CITY OF ALBUQUERQUE

April 24, 2019

**RE: Catalonia Subdivision
Tr 1 & 2, The Trails Unit 3A
Drainage Report Stamp Date: 3/29/19
Grading Plan Stamp Date: 3/29/19
Hydrology File: C09D013**

GIRONA
FROM OFFSITE POND 1 TO POND A

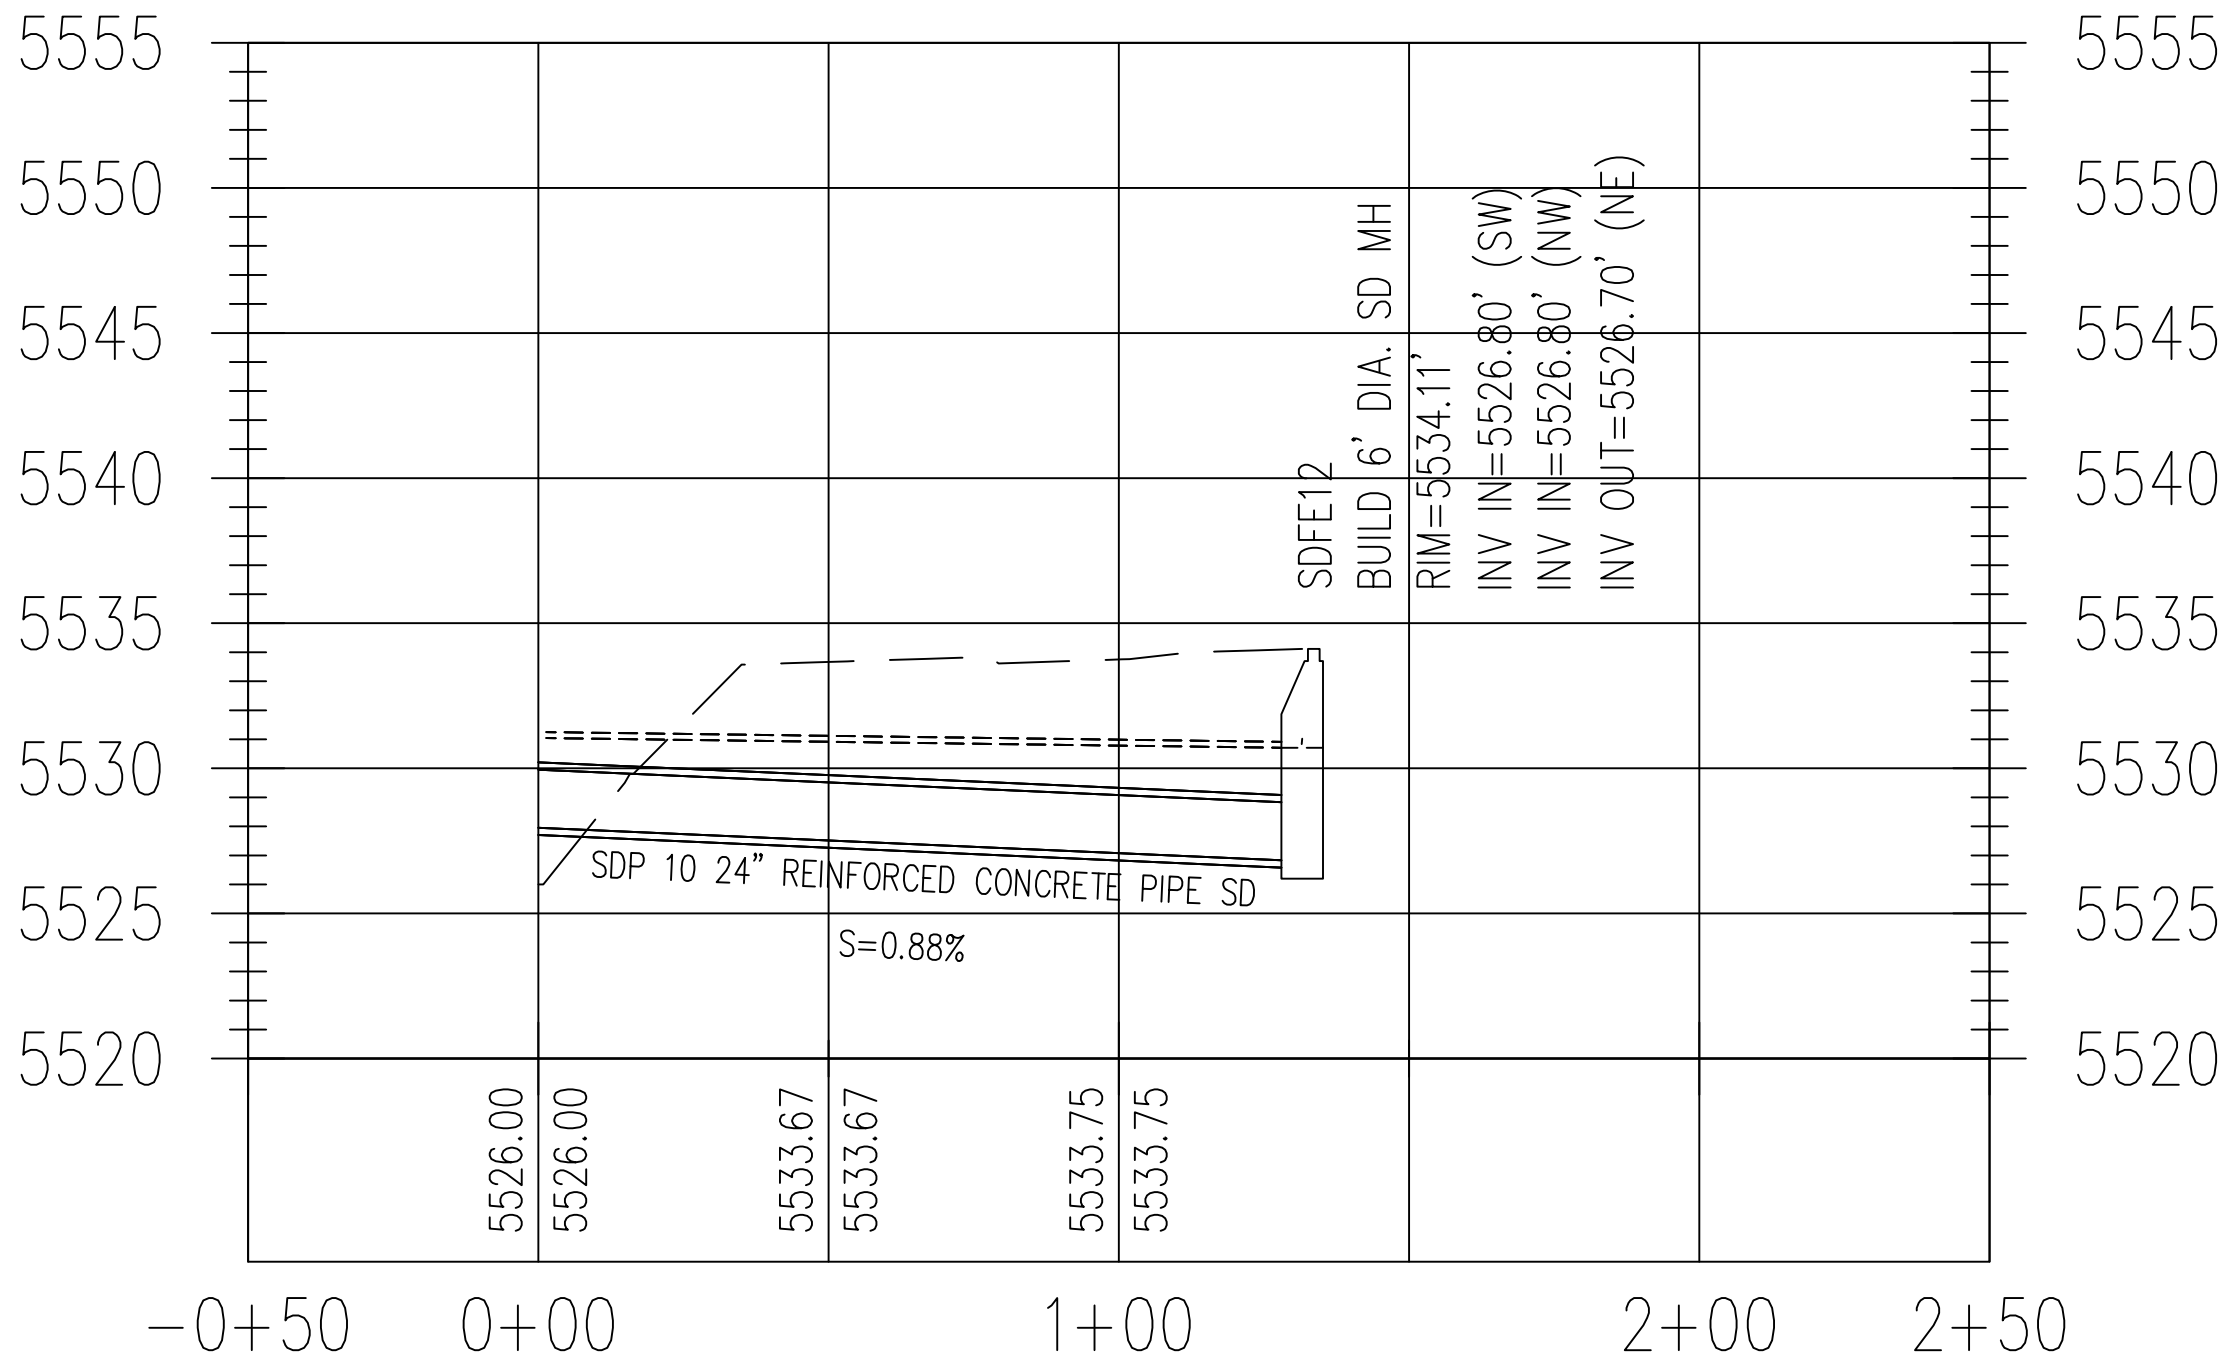
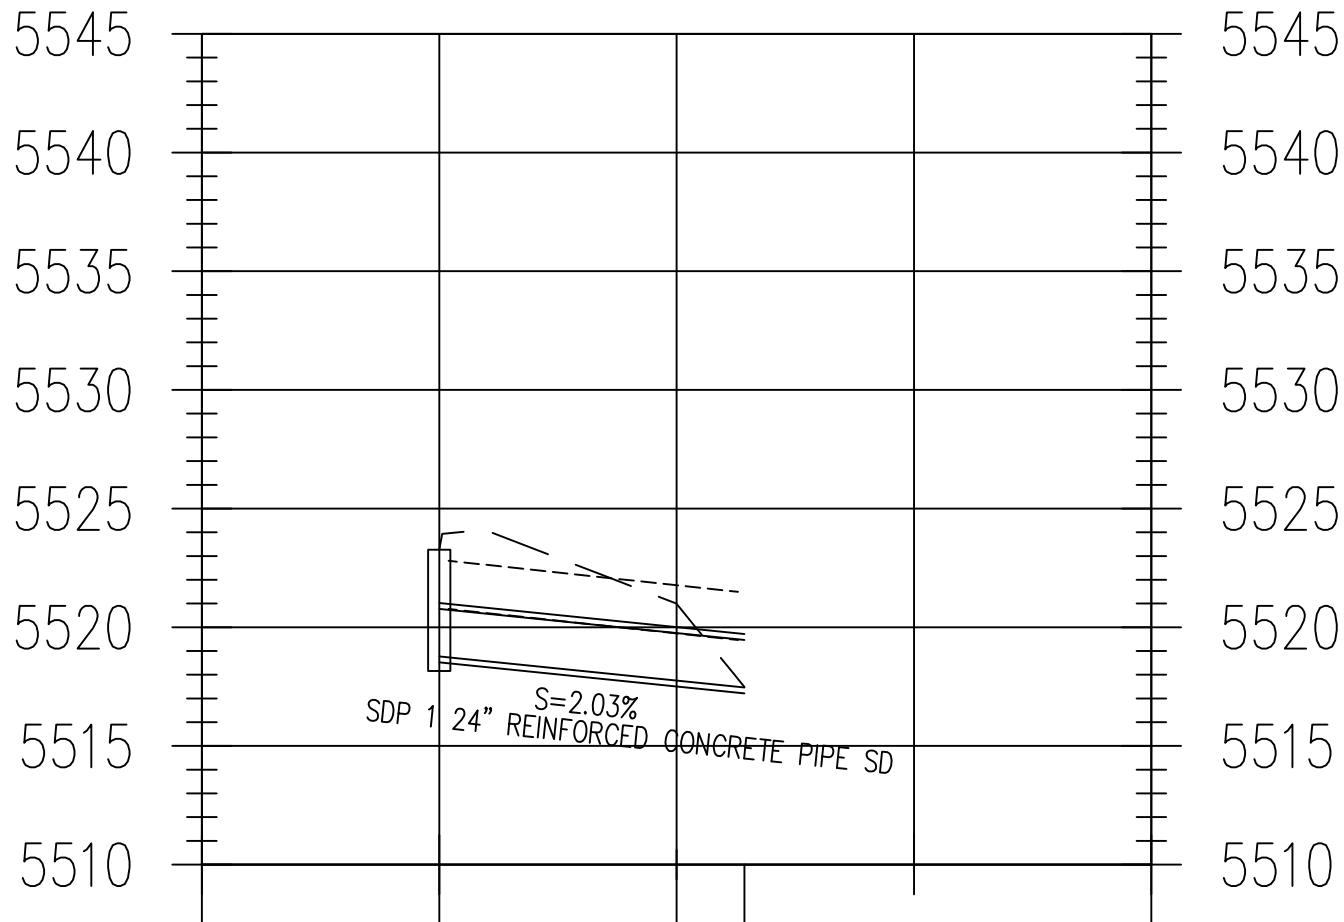
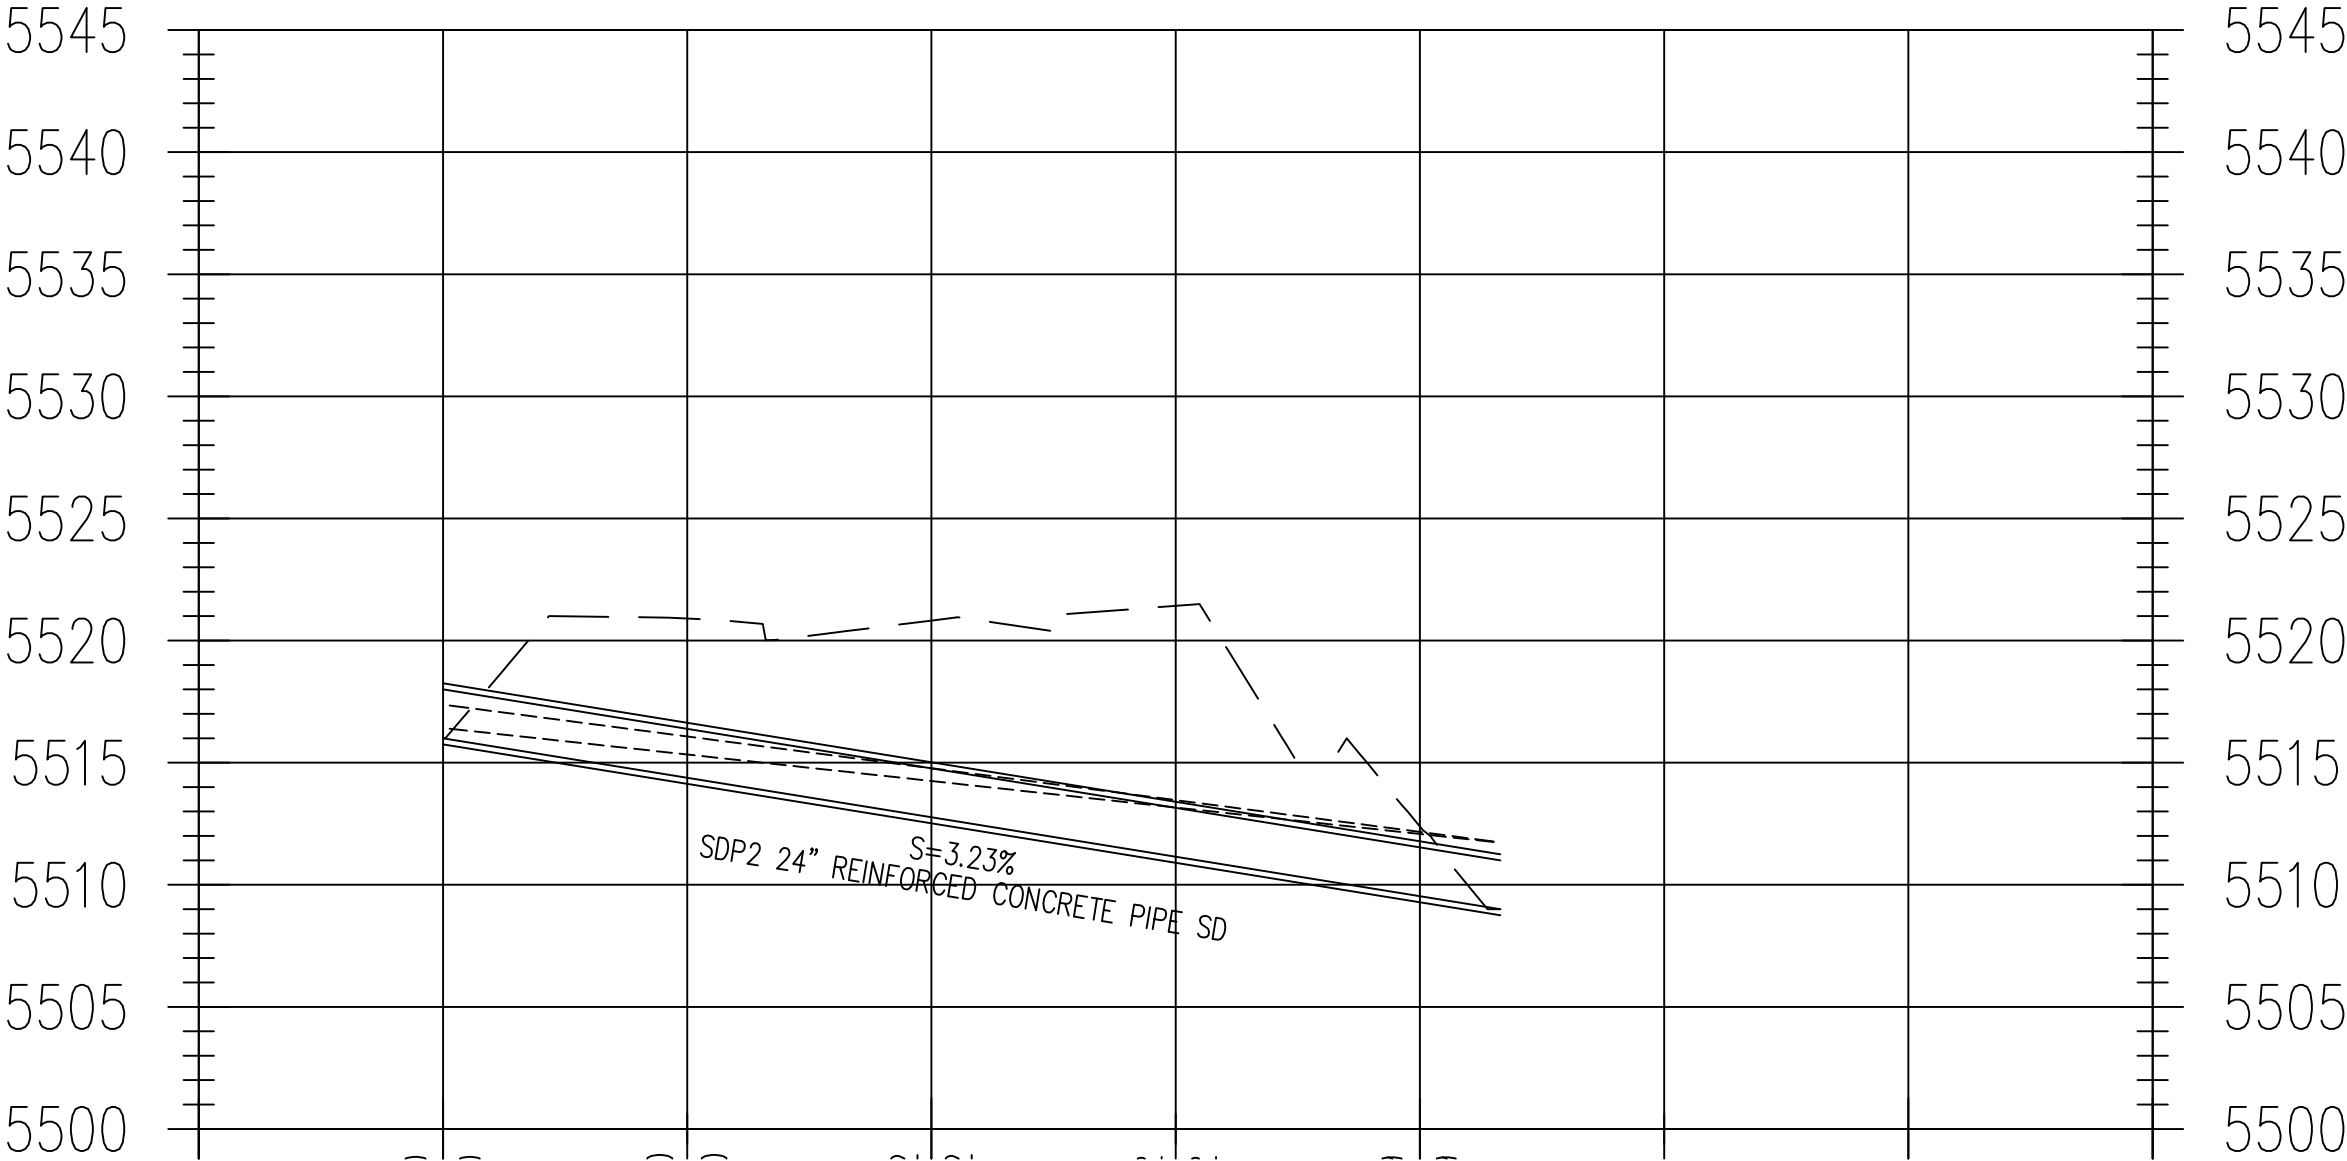
7. Storm Drain Profiles. Appendix C/F.
 - a. Appendix C and Appendix F look to be the same thing.
 - b. Provide a column(s) on the table showing EGL.
 - c. Use the 10-yr water surface elevation (WSE) in the receiving pond as the beginning WSE for the HGL calculations, or the actual WSE, per the pond routing tables (to be prepared).

- d. Transition 1 and Transition 2 will not be allowed; provide manholes at these locations.
 - e. Curvilinear pipe and bends are allowed in select cases; please see attached draft guidance for the new DPM.

- f. HGL profiles are missing for SDP9 and SDP2.

POND A5 EMERGENCY
SPILLWAY

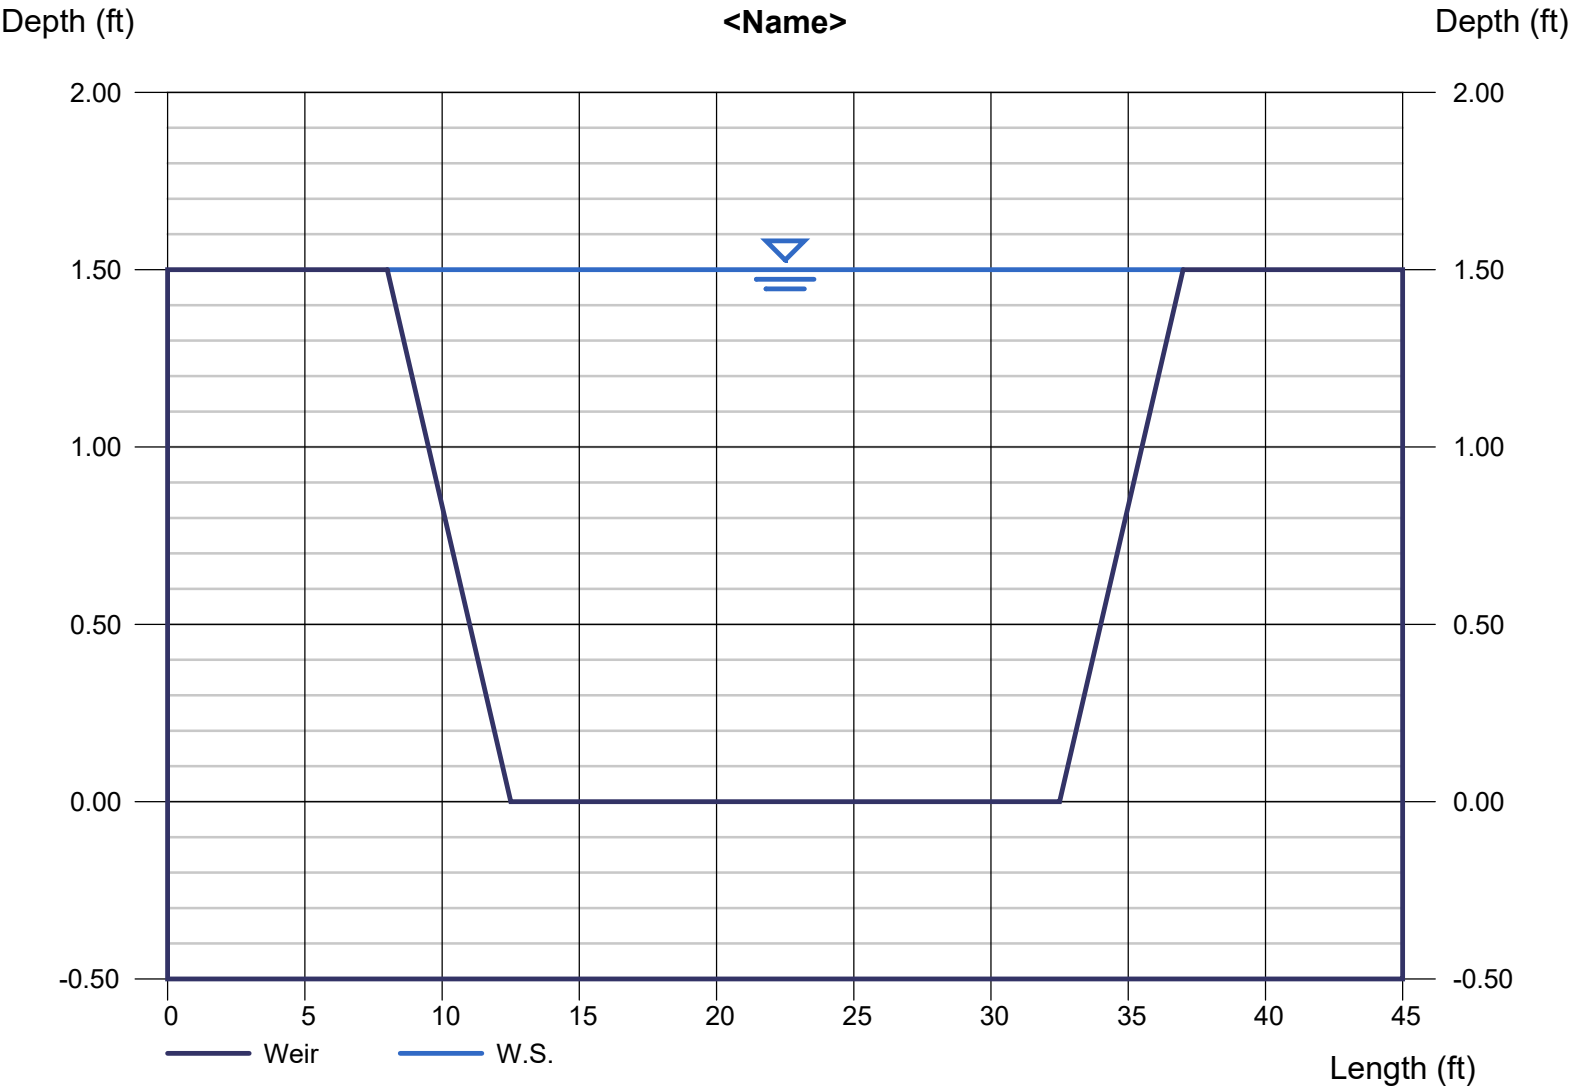
3. Provide Hydraulic calculations for sizing the swale to Offsite Pond 1, the spillway for Offsite Pond 1, and the spillway for Pond B.
4. Inlet/Street Capacity Hydraulics. Appendix B.

- e. You're providing emergency spillways for Pond A5 and Temporary Pond 1, but these typically aren't required if retaining the 100-yr, 10-day volume.
